Application for a non-material amendment following a grant of planning permission.

Alterations to entrance including new doors window and canopy, erection of a single storey rear extension, path, additional car parking spaces and internal remodeling works to allow the change of use from library storage depot and office to a Register Office for the registration of births, deaths and still-births, dealing with legal preliminaries for ceremonies; conducting ceremonies and associated functions.

Reference number:	<input type="text" value="CCC/20/020/FMW"/>
-------------------	---

Scale	1 : 100 @A1	Date	03.03.2021	Drawn	SD
Drawing Title	<b>Elevation Proposed</b>			Checked	DY
Drawing Number	<b>J4523-YMD-01-ZZ-DR-A-3100</b>			Revision	P2

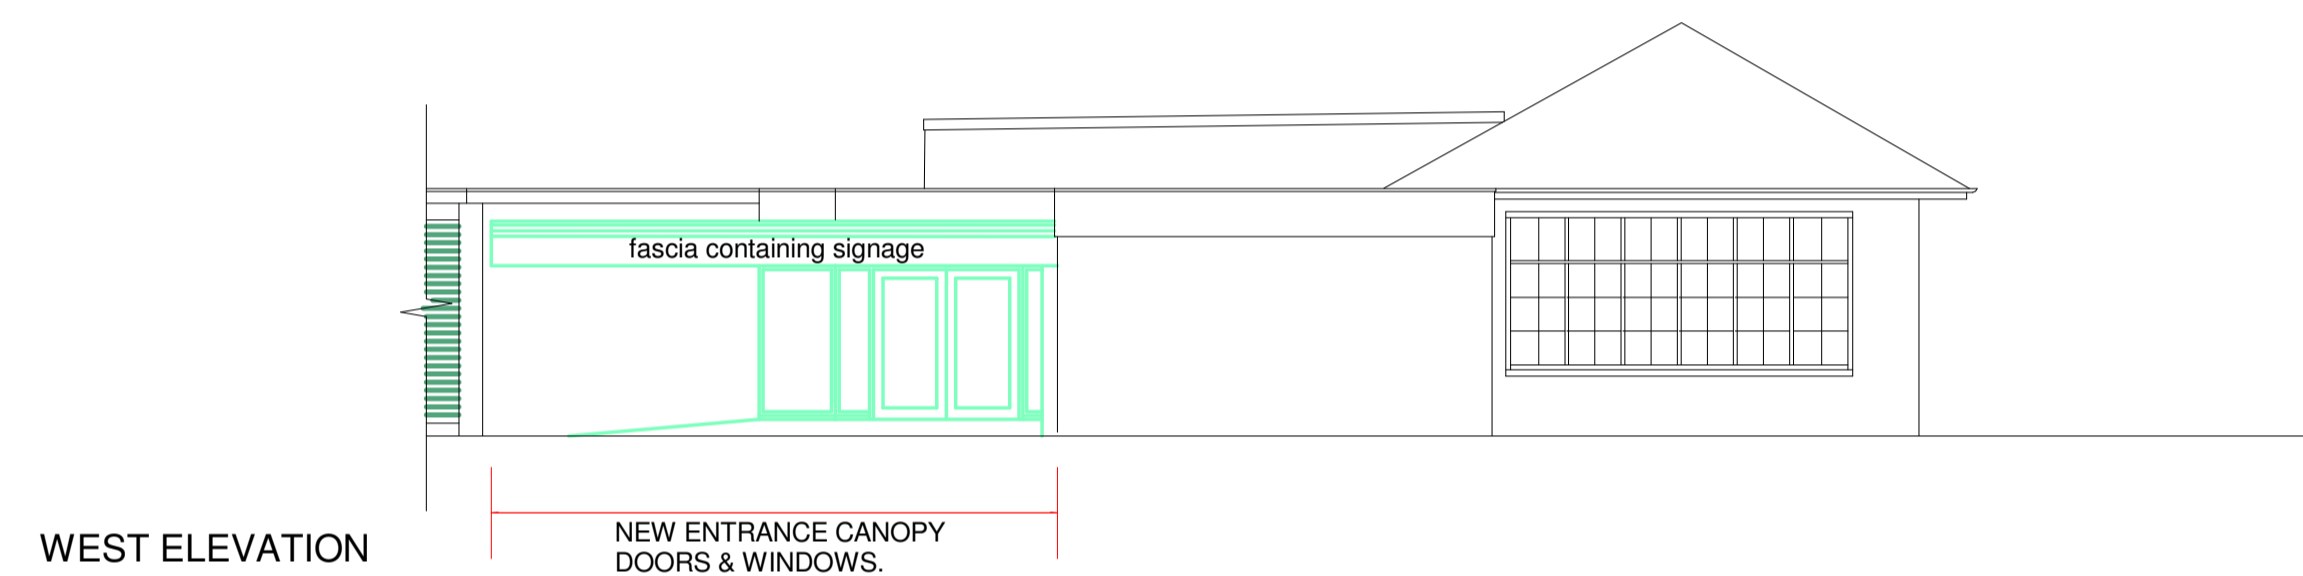
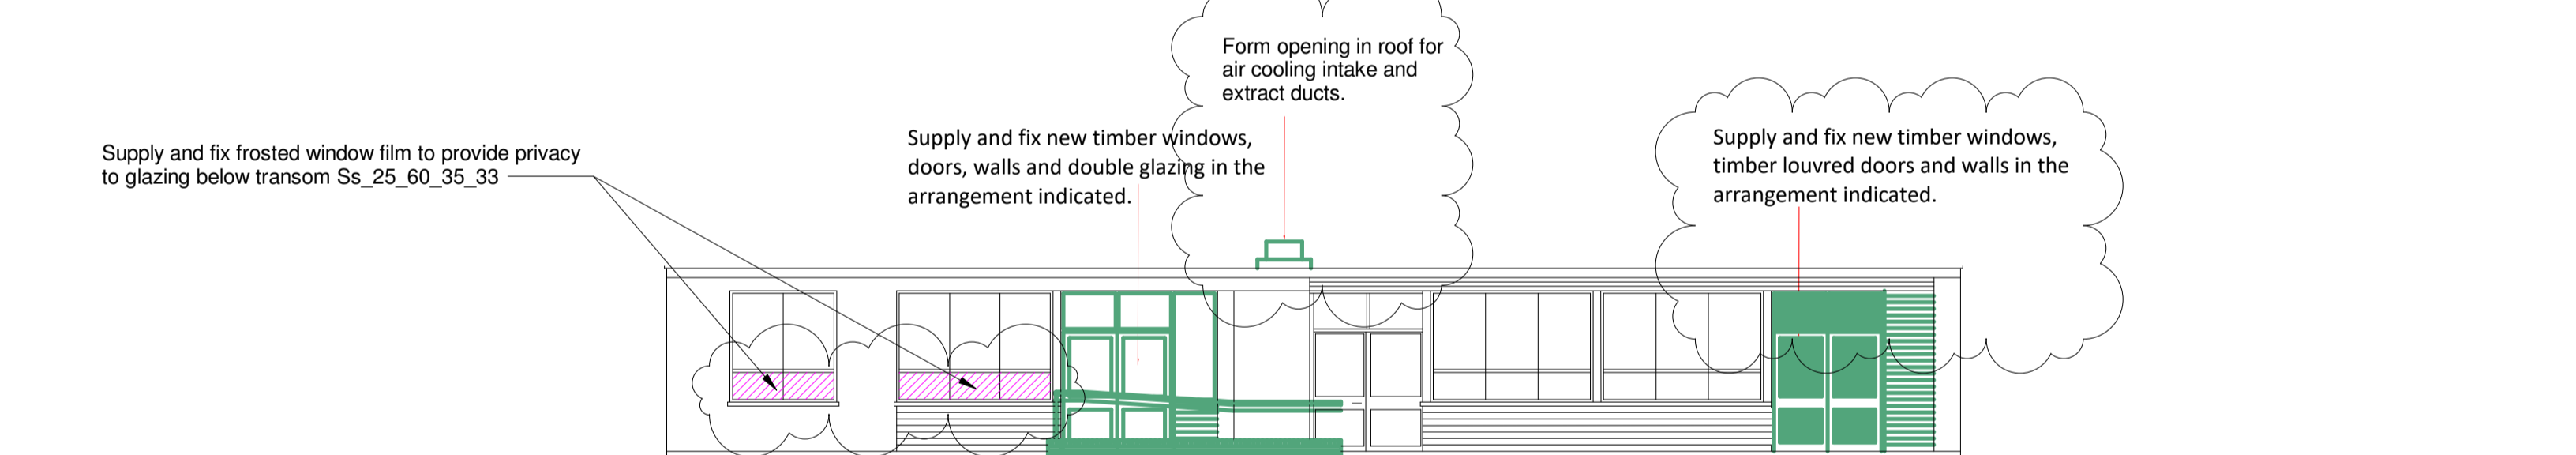
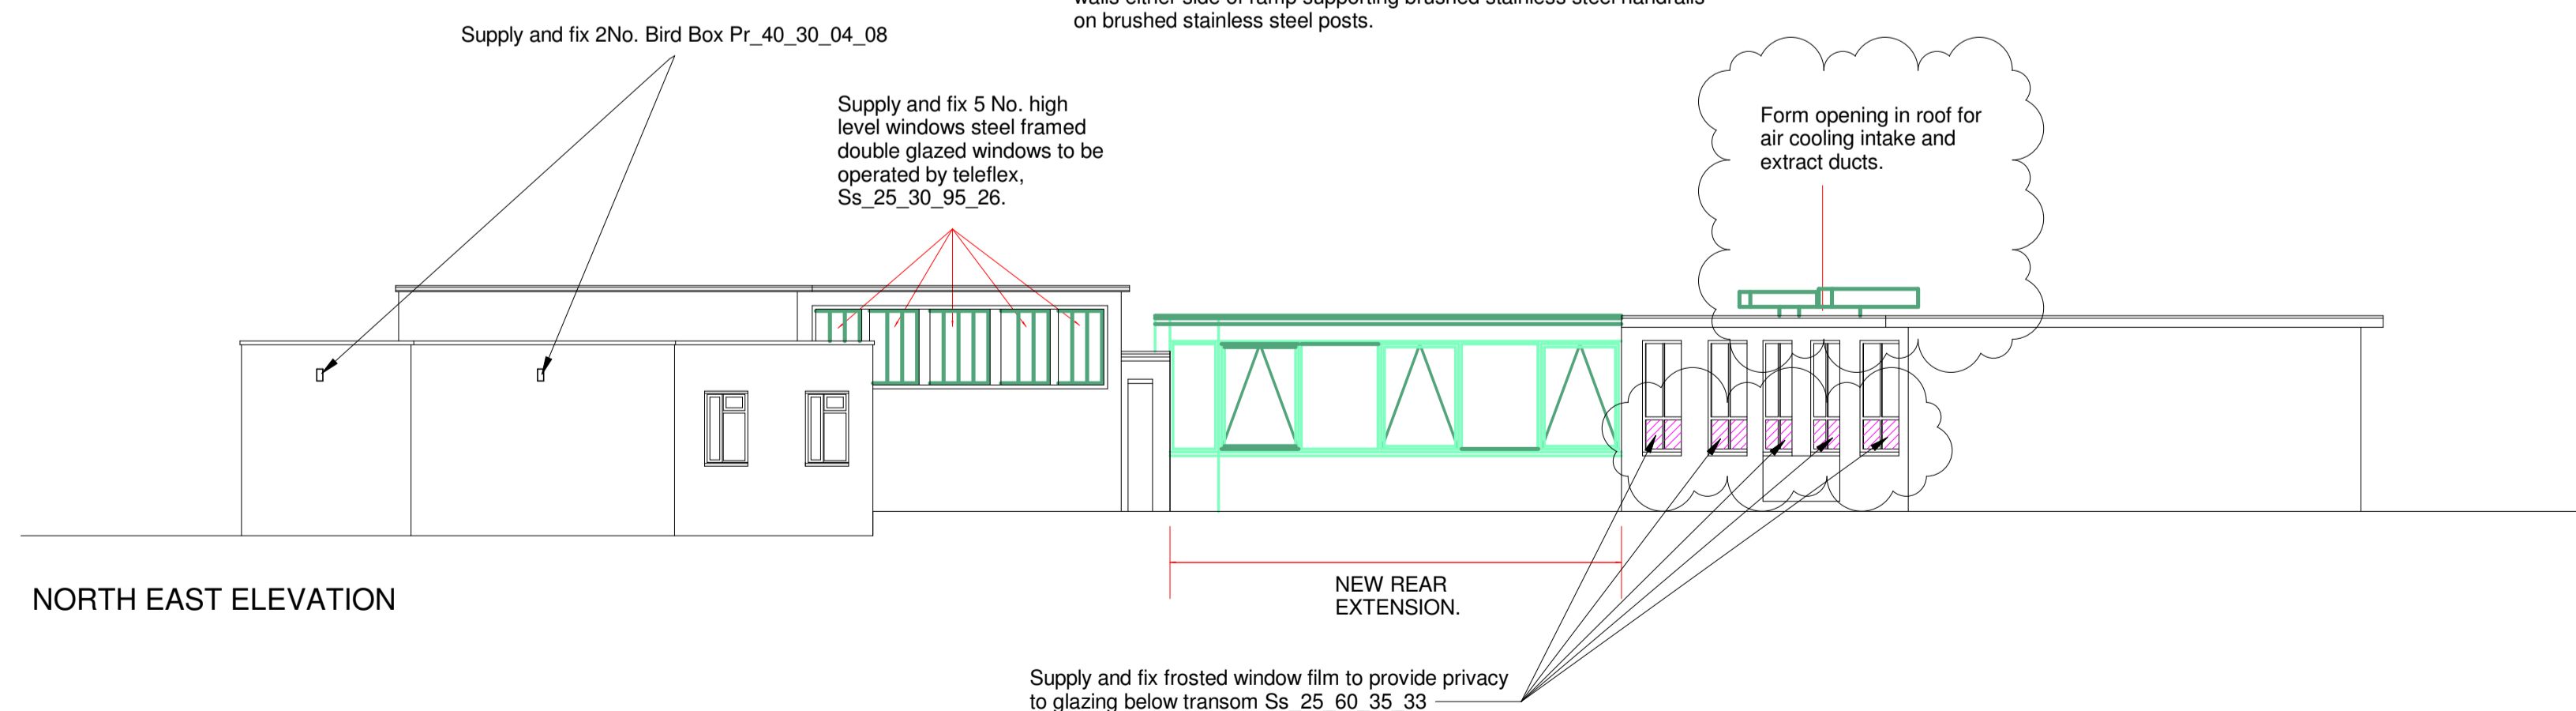
5. Windows; Secure Store Room/Safe Room 28 windows left intact, windows to be secured with internal railings not shutters. Plant Room 4 external doors updated and external wall infill proposal changed to with existing structure. New windows/doors proposed to Entrance Lobby and Reception/Waiting 2. New high level metal framed windows proposed to be installed to Interview 1, Interview 2 & Interview 3. All other existing windows to be retained and secondary glazing installed. Windows to toilets 13, 14, 15 & 16 which are internalised by new rear extension removed and openings infilled to provide adequate acoustic privacy to toilets.

10. Roof ducting; Required intake and extract ducts on roof of Ceremony Room/Ceremony Waiting block.

5. Windows; Secure internal railings proposed in lieu of shutters in safe room to provide free flow of air and avoid potential for condensation with potential to damage windows. Existing windows replaced or to have secondary glazing to improve thermal performance of building.

10. Roof ducting; Roof ducts required to supply fresh air and extract to air conditioning units servicing the Ceremony Room/ Ceremony Waiting rooms. Air conditioning essential for these rooms to ensure that windows are not opened in these rooms when being used for ceremonies, to ensure proposals compliant with planning requirements.
